NOTIFICATION FROM ARUN DISTRICT COUNCIL
Town & Country Planning Act 1990 (as amended)
Town and Country Planning (Development Management Procedure) (England) Order 2015
Planning Permission
APPLICATION **R/284/17/PL**

Registered: 11th January
2018
Site Address: 62 Ash Lane Rustington BN16 3BT
Grid Reference: 505496 102540

Description of Works: Convert existing garage/studio space into a 2 bed. short term holiday let. Removal of small section of existing flint wall to the section adjoining the garage (approx 3m) to create garden access & off road parking - This application affects the setting of a Listed Building

Drawing Name: Additional Parking
Drawing Number: 018

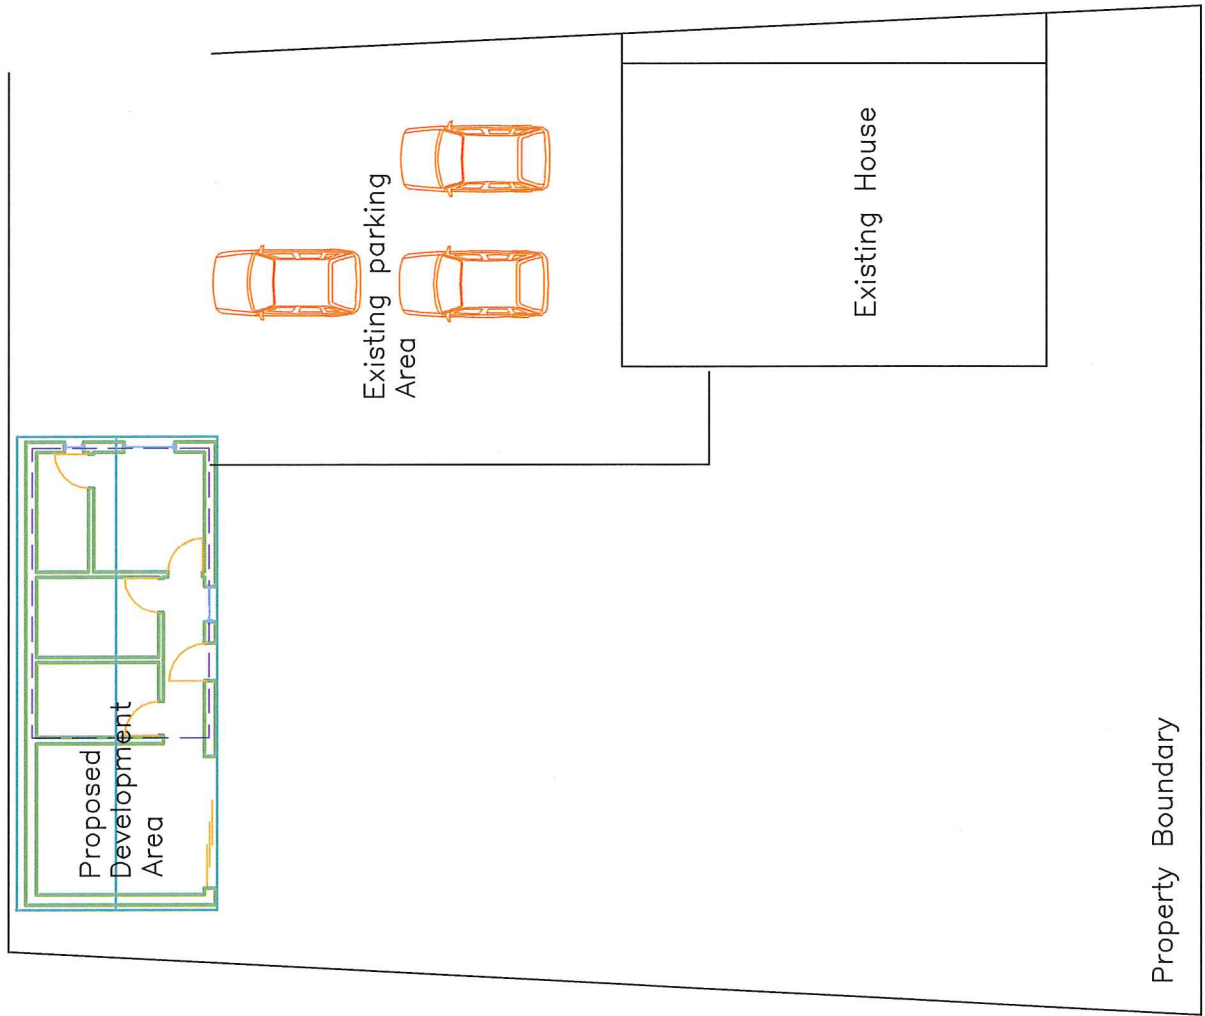
Hi Anita –I don't believe that the proposed conversion of garage to holiday let would in itself be harmful (it already houses a gym and has full-height French windows etc...), I resist the removal of the flint wall, which I presume to be listed and part of the original house. The requirements for the airbnb – eg extra parking etc, may harm the setting, although that's also fairly marginal.
